Our Case Number: ACP-323849-25

**An
Coimisiún
Pleanála**

Re: The proposed development is for a mixed use development that seeks the regeneration and adaptive reuse of a strategic brownfield site, as part of the Limerick City and County Council 'World Class Waterfront revitalisation and transformation project' 'Cleeves Riverside Quarter' in the townland of Farranshone More in Limerick City.

Subject: Objection to planning application : JH91.323840 and JA91.323849.

Drawing file: 13 - 15. Site Location + Arch. Drawings / Salesians - Existing and To Be Demolished - First Floor Plan.pdf

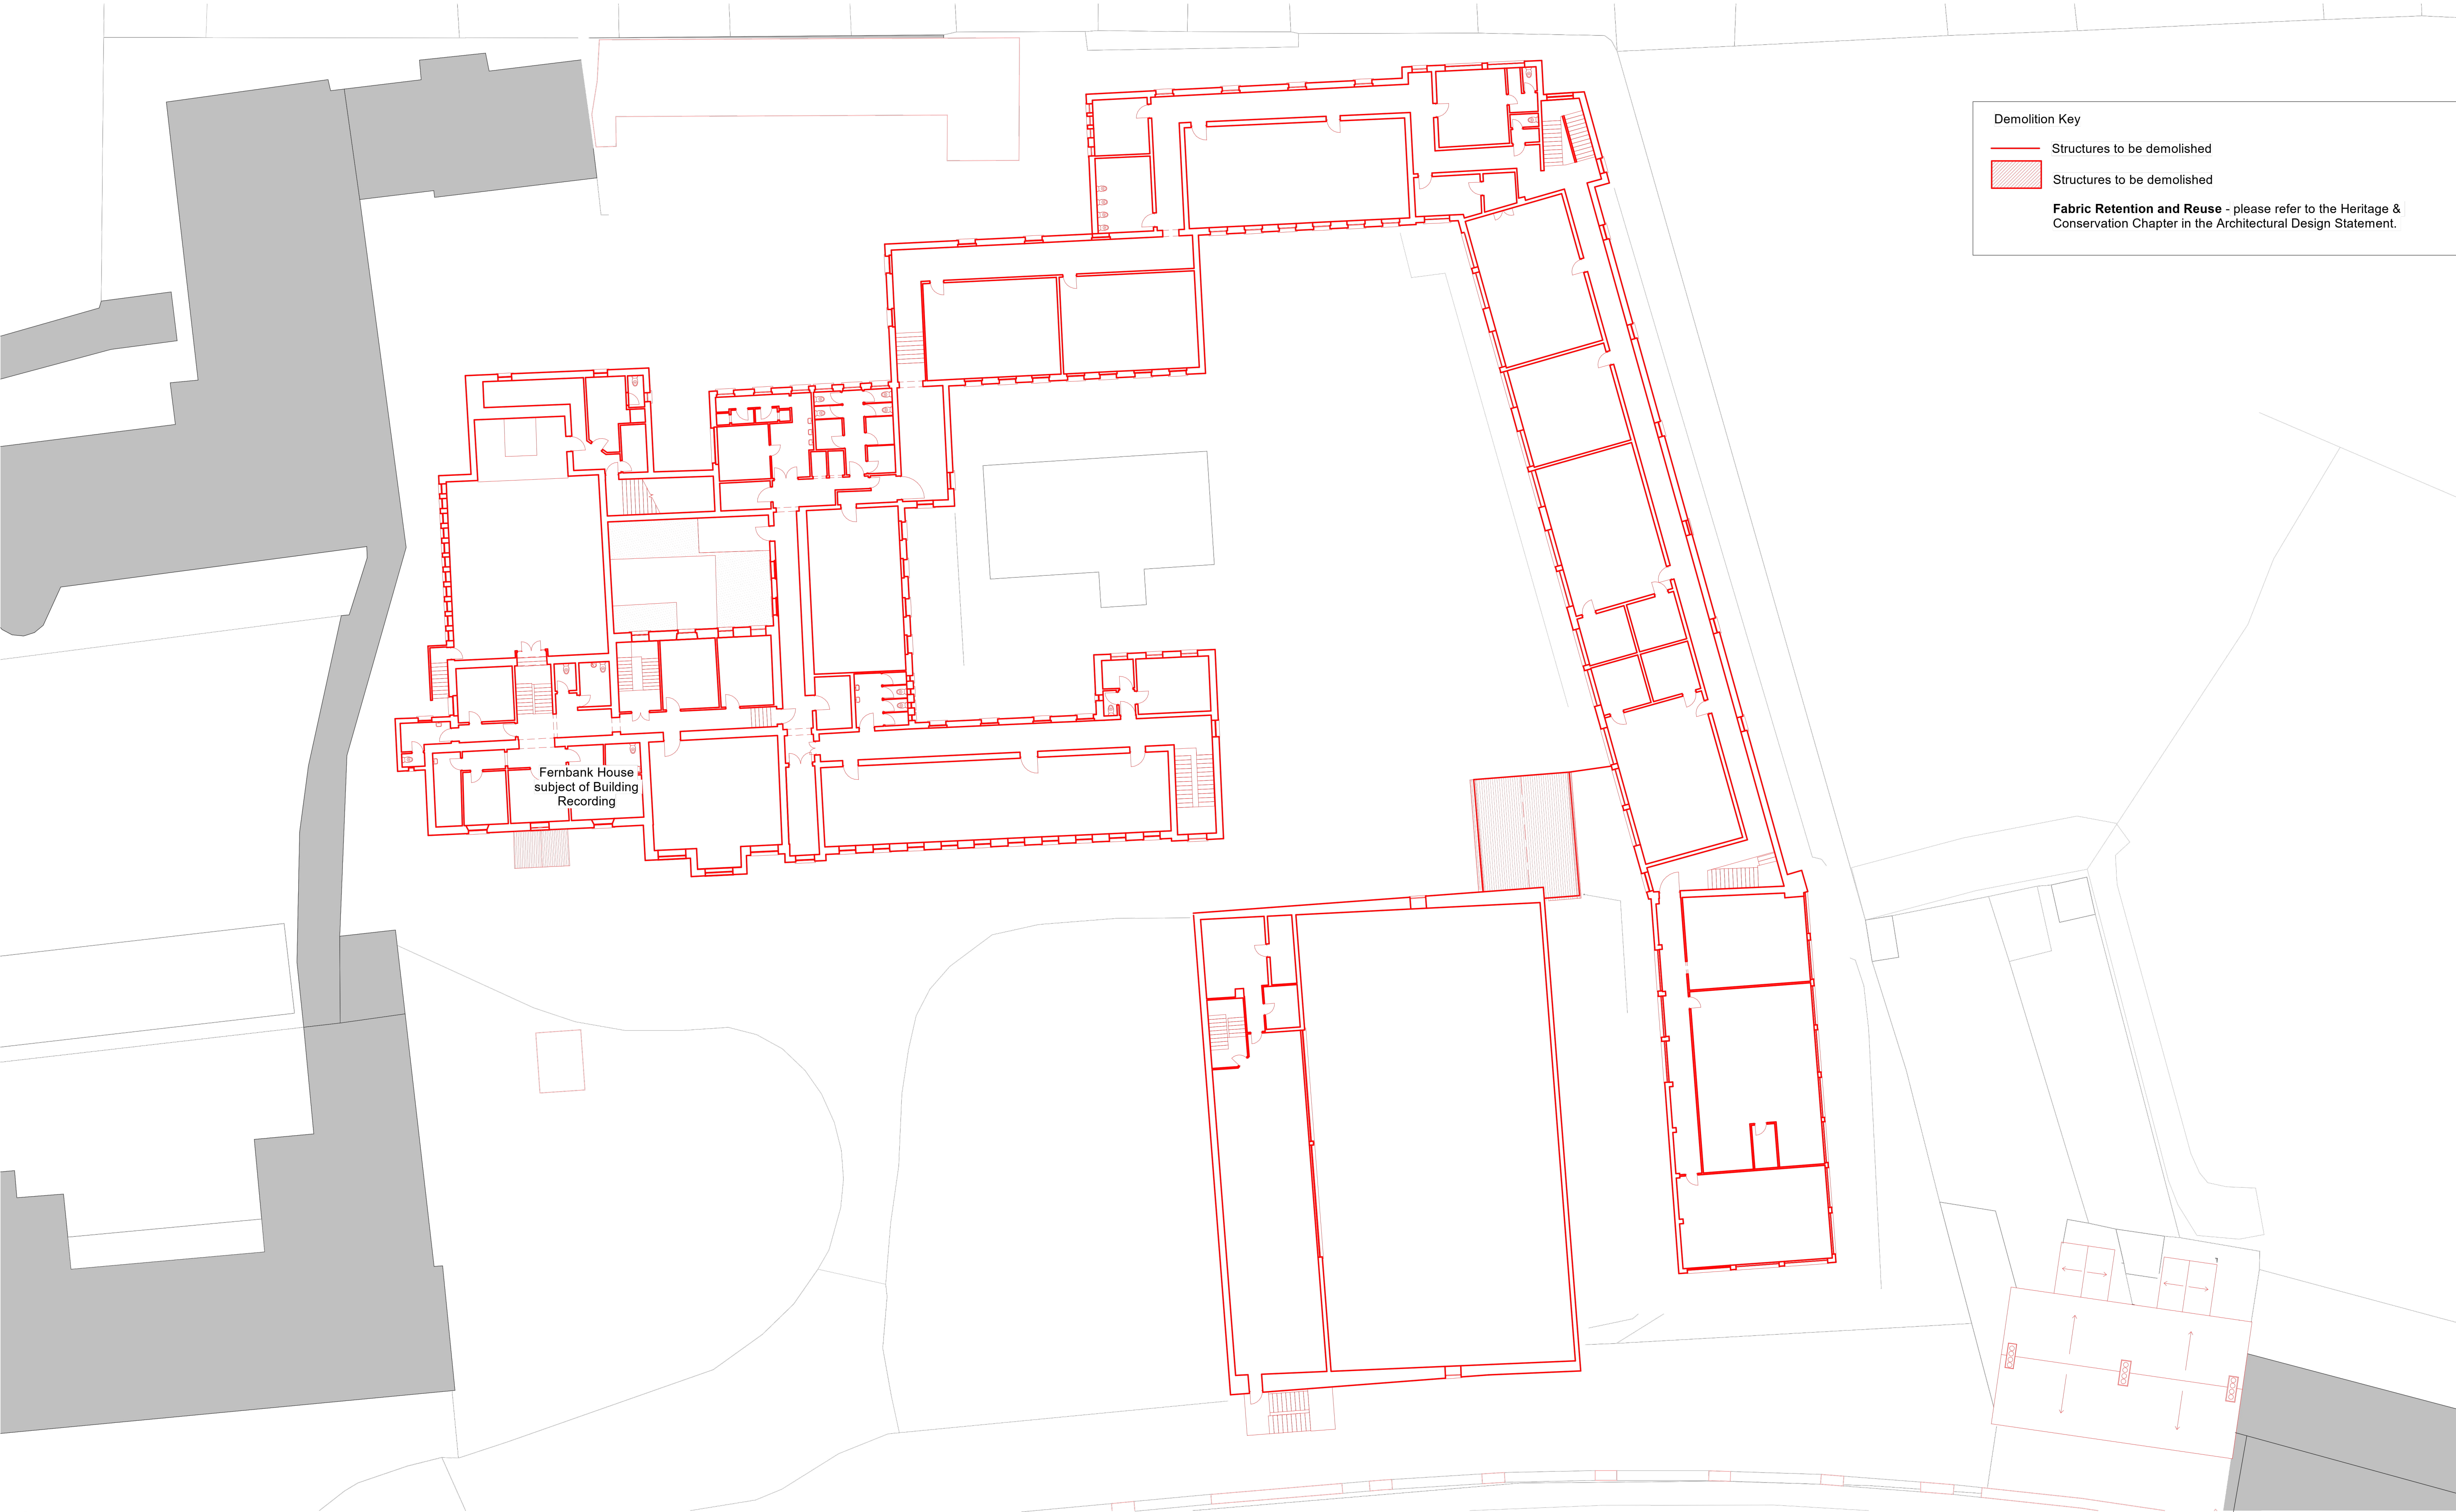
- **Harm to the setting of a building that should be listed as a protected structure:** The proposed development requires the destruction of Fernbank House, which is an architectural gem.

- **This vernacular architecture has for the past 155 years includes the villa of Fernbank House, the home of the Cleeves Family and an important early building on the north side of the river Shannon in Limerick City.** This proposal fails to respect the existing historical context and violates local planning policies that aim to preserve and enhance conservation areas. The fact that the owner, the local authority, has not listed this building despite its noted historic value is a problem in itself. It should be protected as a matter of urgency.

- **In the application no mention of this building is made.** It is to be demolished as per the plans. However this was one of the first buildings on the north side of the river bank at Limerick from 1800- onwards. It is a vital piece of our history as a merchant and trading city.
